Application by The Drovers Solar Farm Limited for The Drovers Solar Farm

The Examining Authority's written questions and requests for information (ExQ3): Issued on 29 September 2026

PINS Ref. EN0110013 Drawing no.: 9485_0538

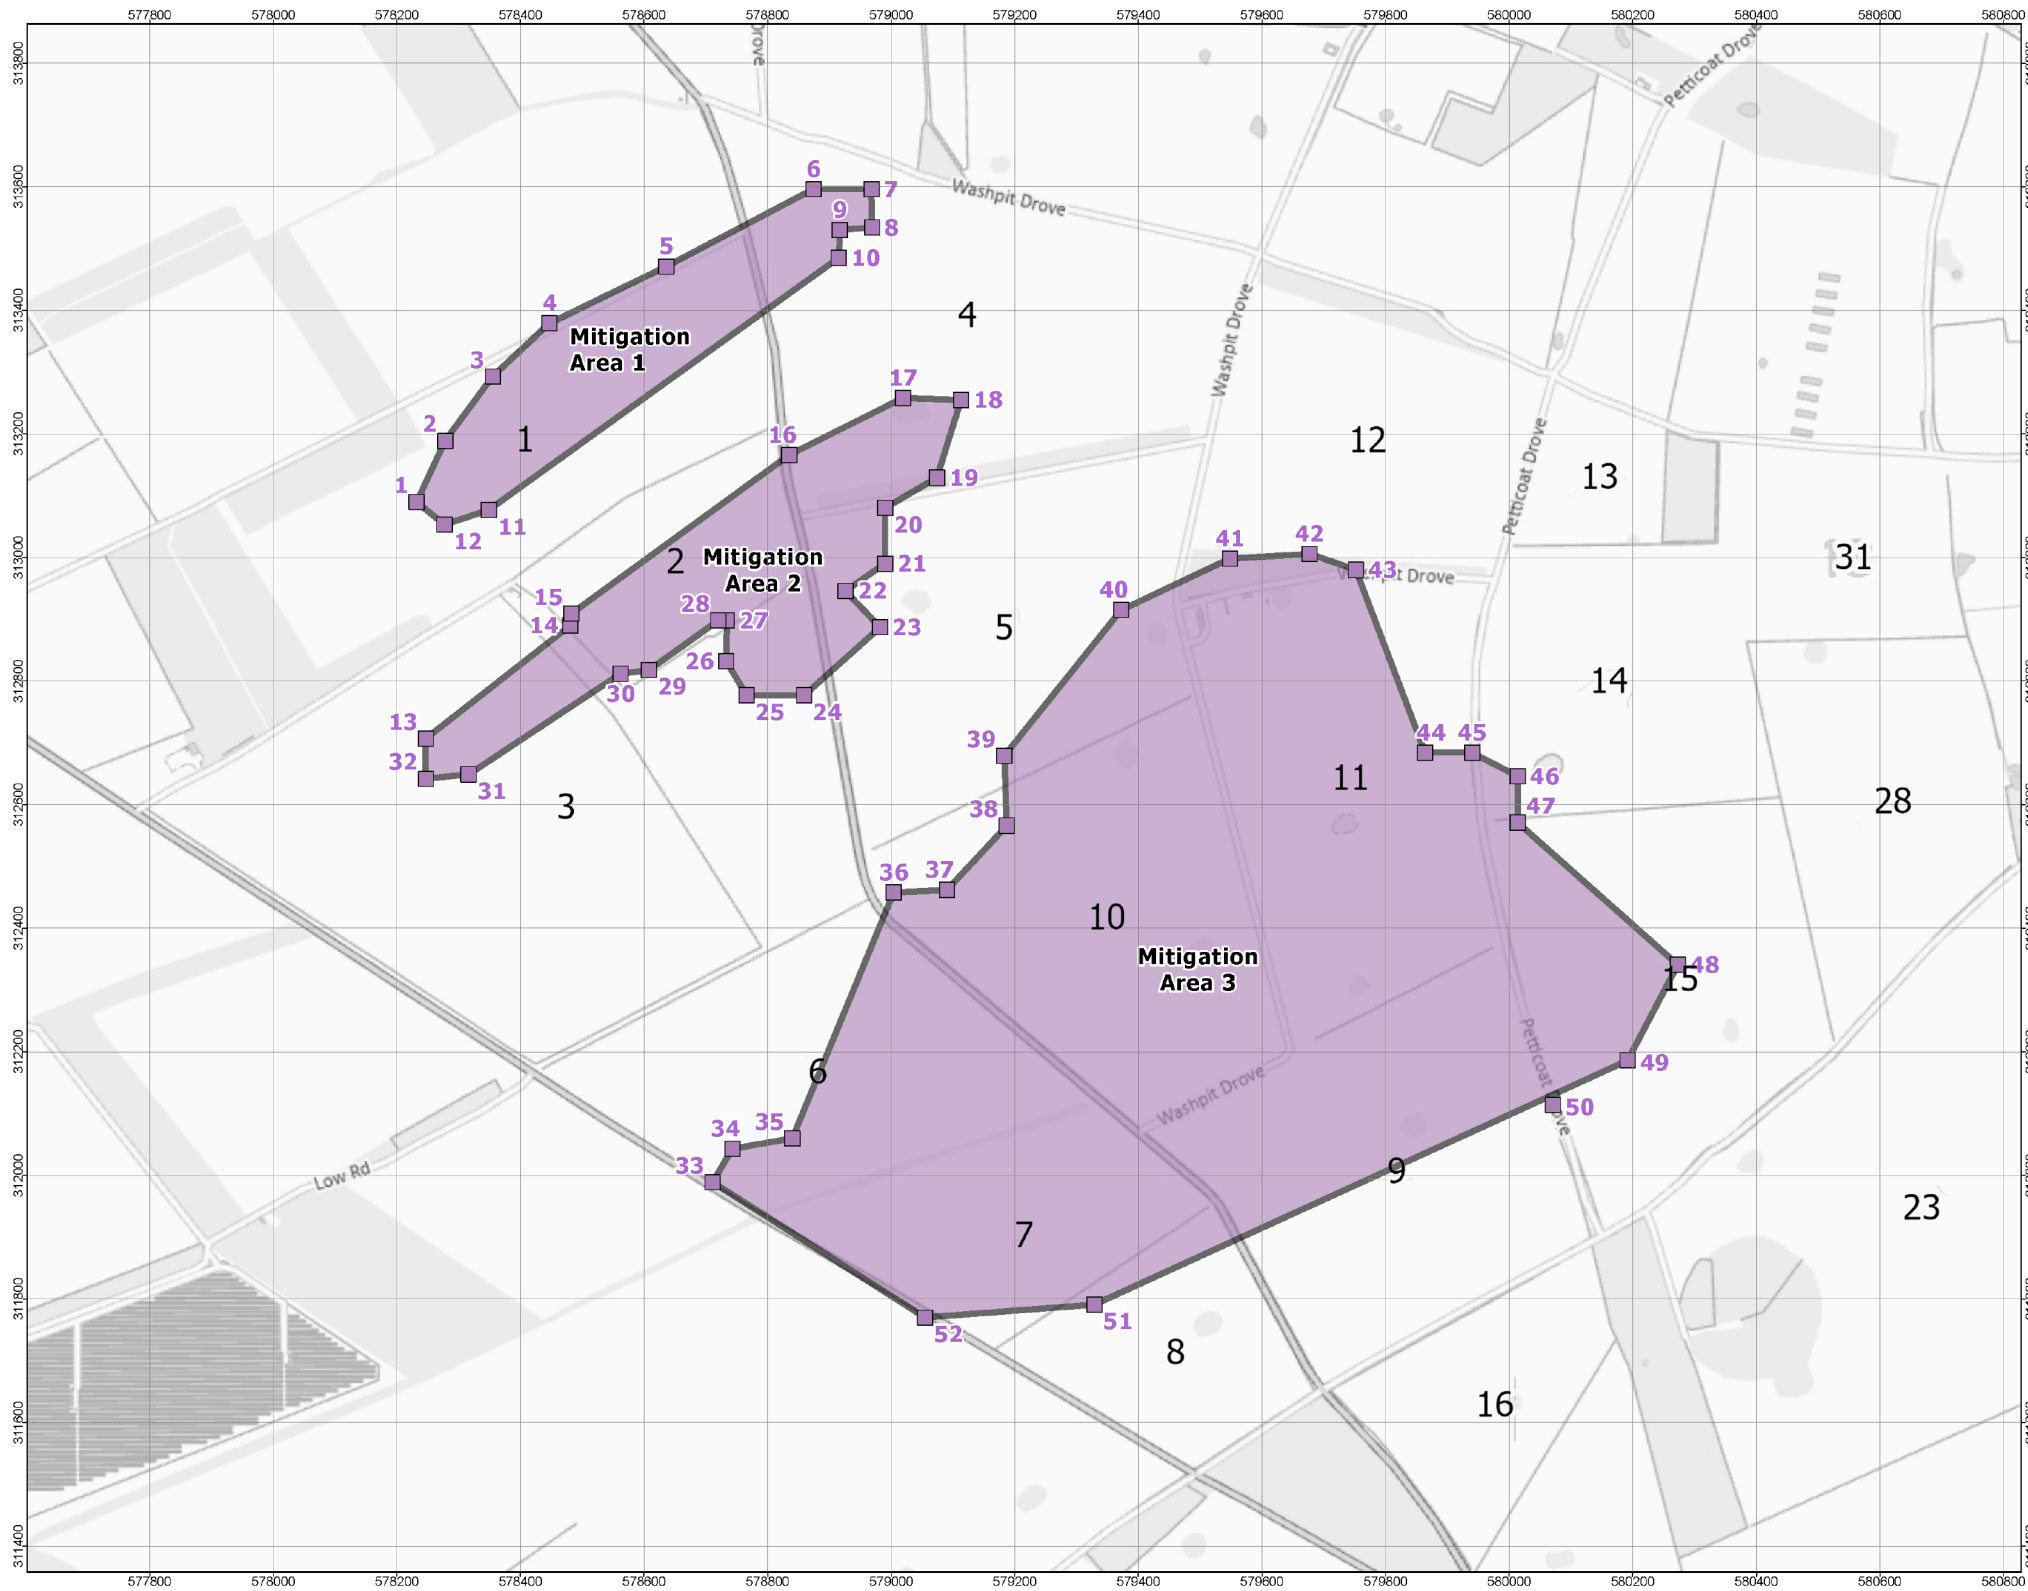
ExQ3	Question to:	Question:
11.	Landscape and visual	
Q11.0.1	The applicant	Design of mitigation areas for RAF Marham's precision approach radar (i) Could the applicant comment in detail on how the design of the RAF Marham Mitigation Areas Plan [REP4-039] would be integrated with each of the existing and proposed features shown in the existing Appendix 1 – Green Infrastructure Strategy Plans, outline Landscape and Ecological Management Plan (oLEMP) [REP3-070] and provide updated plans for Appendix 1 to take account of the PAR mitigation areas? (ii) What factors would be considered to determine the design choice of bunds and/or fencing for the mitigation at each location and how would transitions be designed between different types of bunds and/or fencing? (iii) How would the above design choice align with the Design Principles in the Design Approach Document [AS-009] to [AS-011], and the oLEMP's ten strategic landscape and ecological opportunities (referred to in applicant's response to ExQ1 Q1.0.4 [REP1-069], which set a framework for the operational landscape and ecological management of the Scheme)?
